Our Ref: BE/51/18/PL
Your Ref:

3rd May 2018

Town & Country Planning Act 1990 (as amended)
Town and Country Planning (Development Management Procedure) (England) Order 2015
Application for Planning Permission

Development 1 No. dwelling. This application is a Departure from the Development Plan.
Location Springfields Chichester Road Bersted

PROJECT:
Springfields
CLIENT:
Mr C. Thorpe
TITLE:
Proposed Site Layout - Point 227E

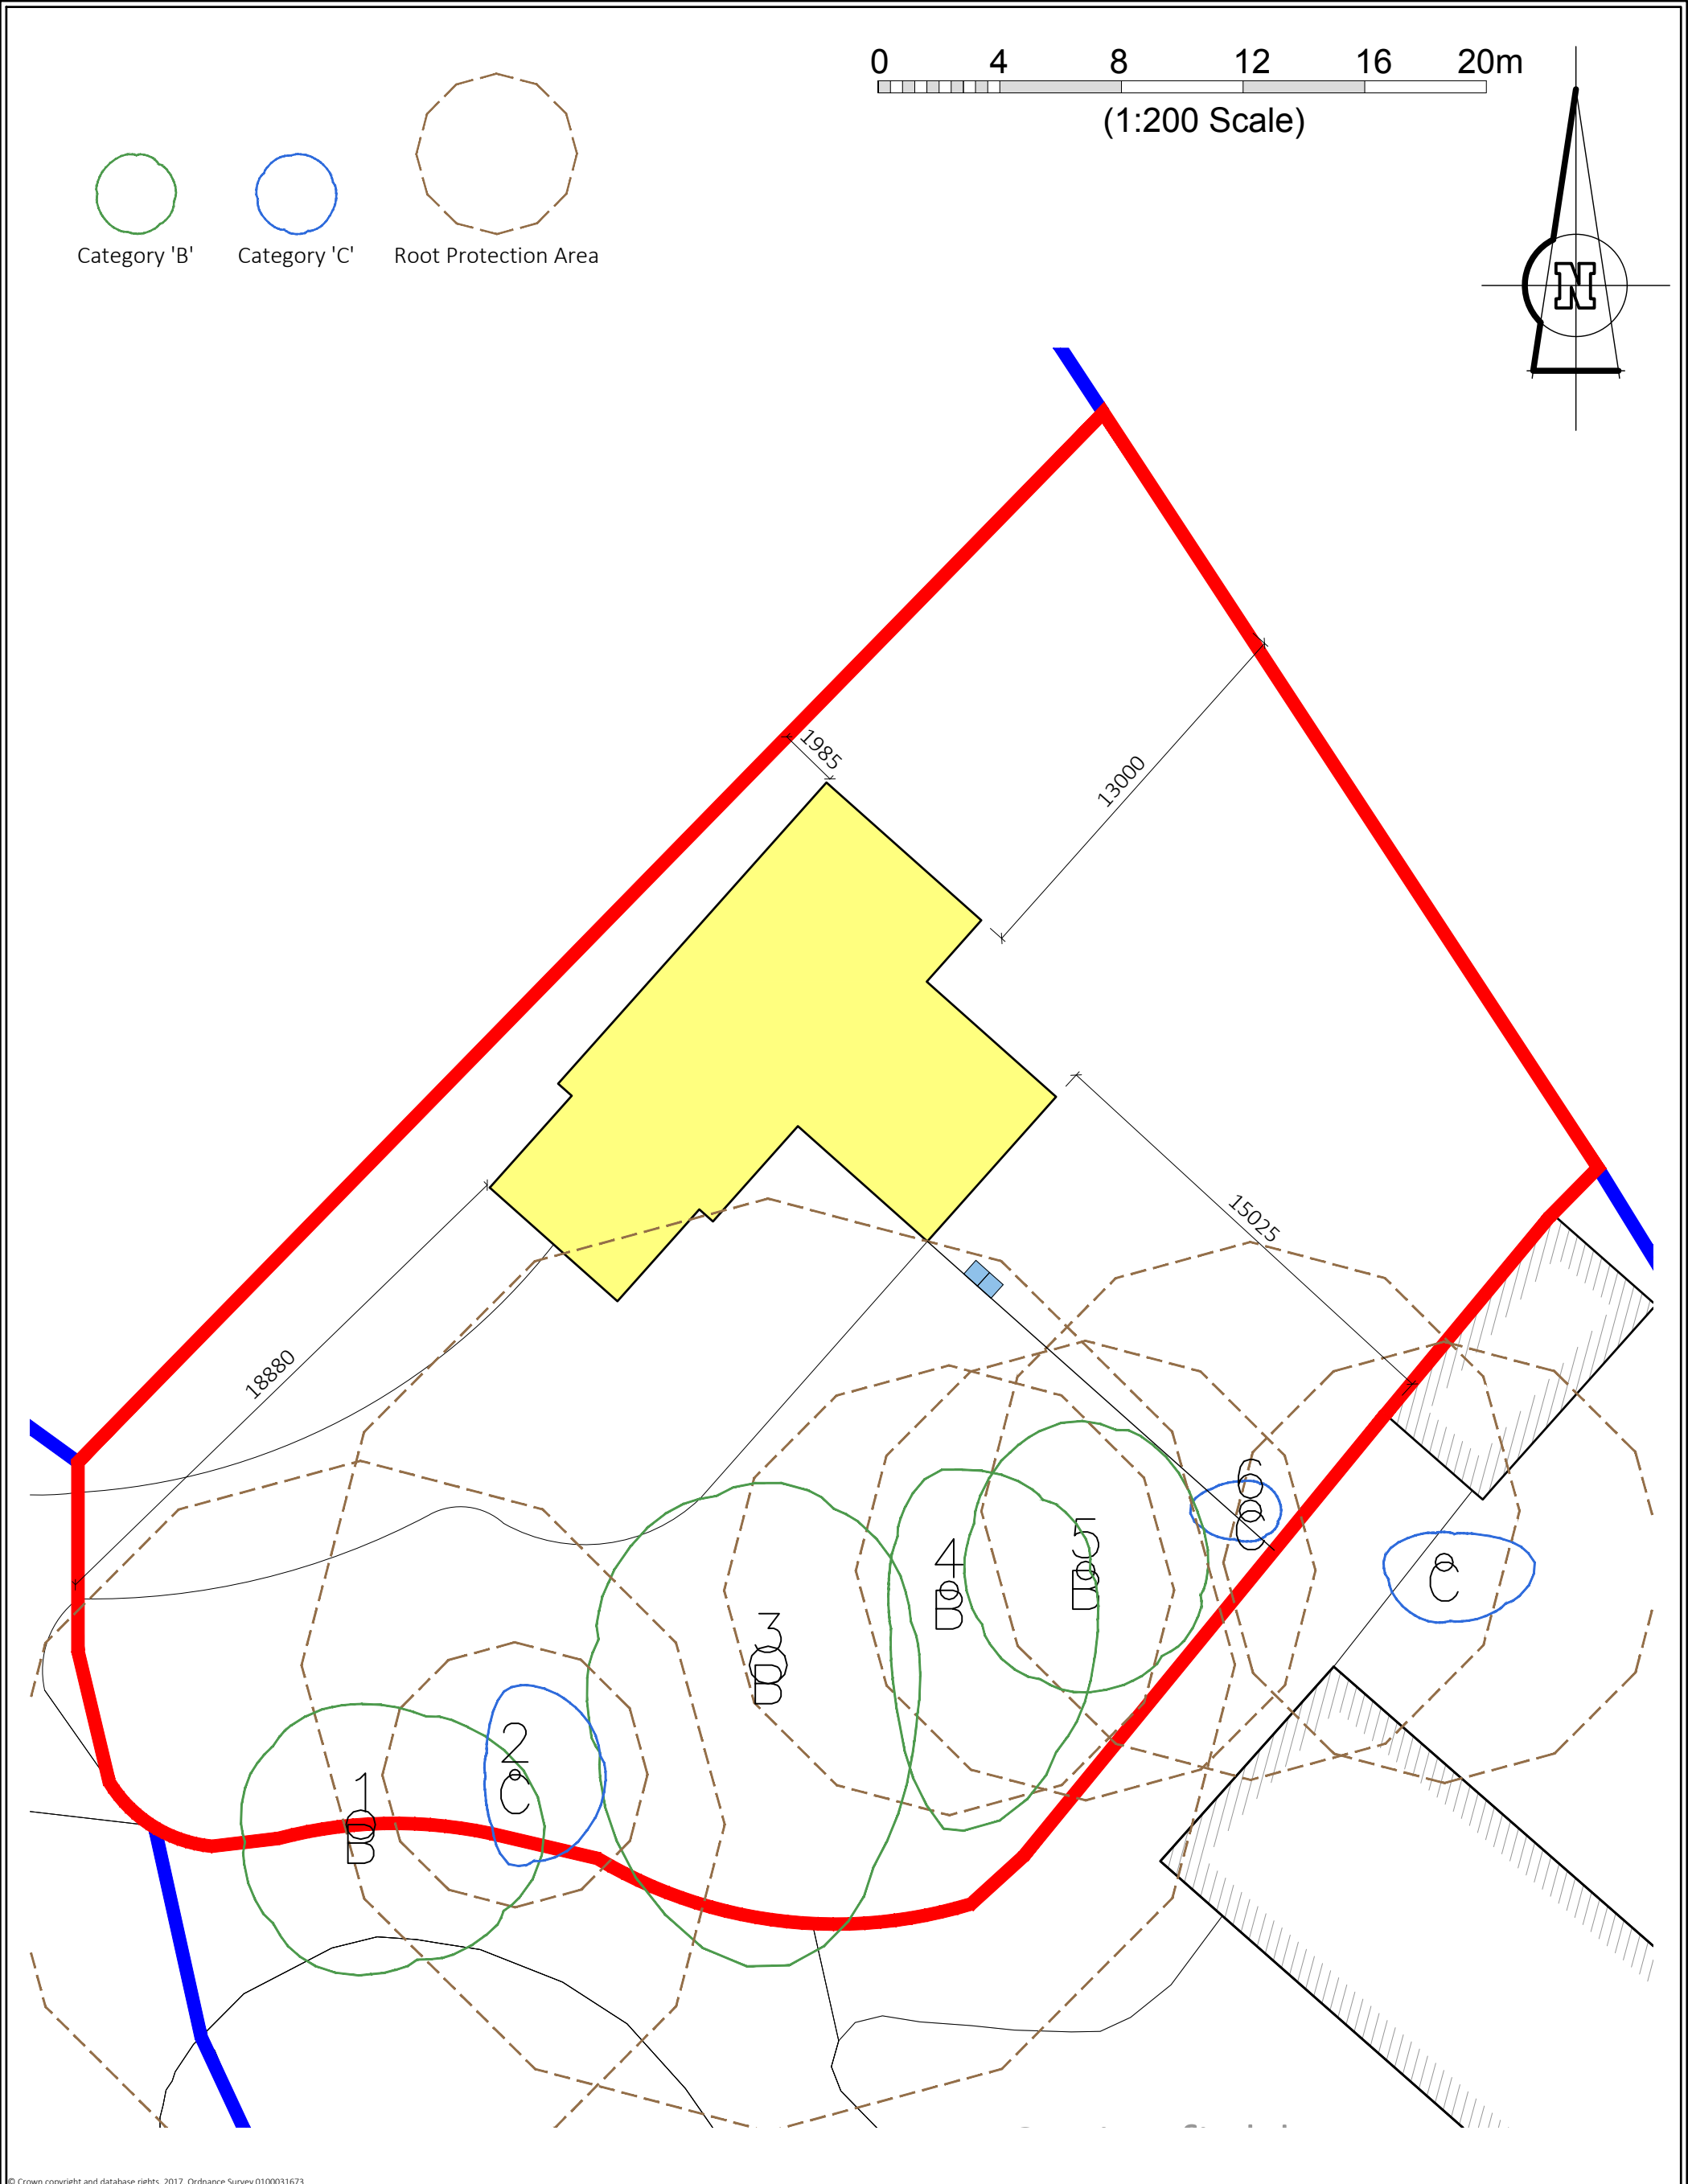
Block Plan Amend

Please submit 1 electronic or 3 paper copies of a block/site plan at a scale of 1:500 or 1:200. Further details of what must be included on the plan can be found in the National Validation Requirements. Please provide dimensions from the proposal to the site boundaries.

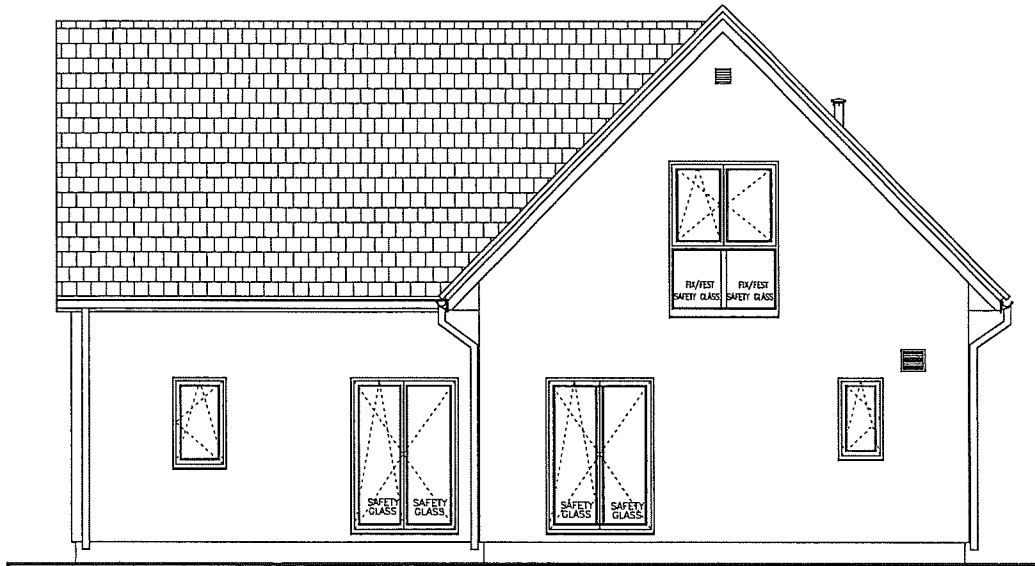
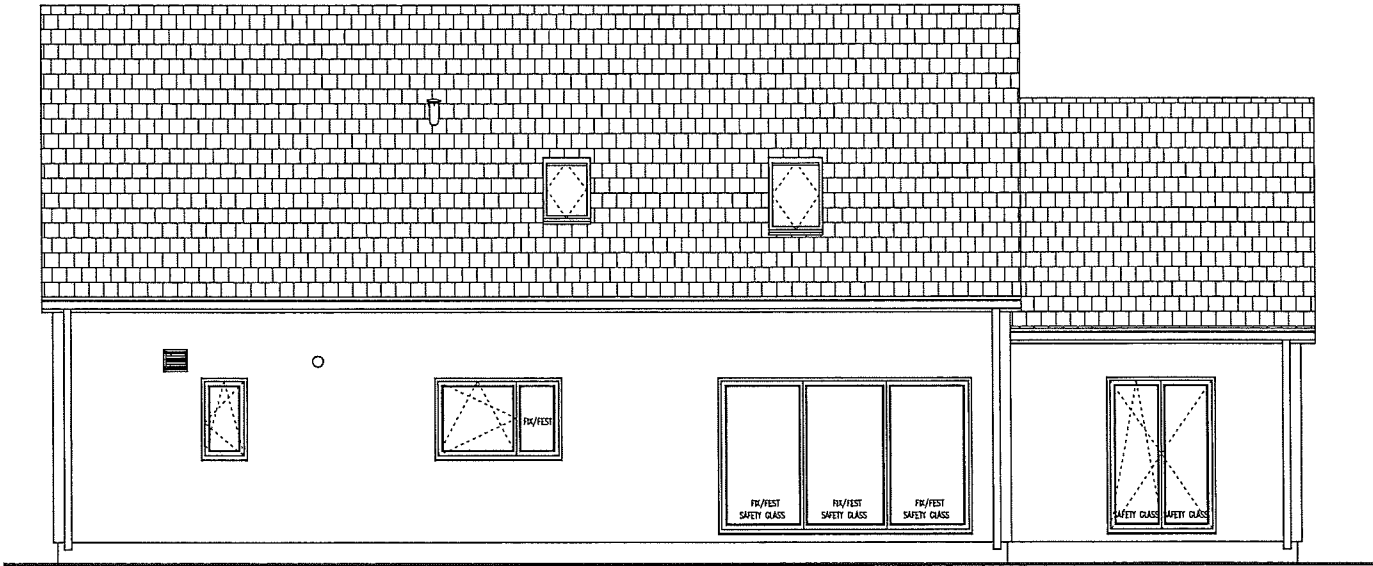
Please label the proposed elevations north, south, east and west as appropriate.
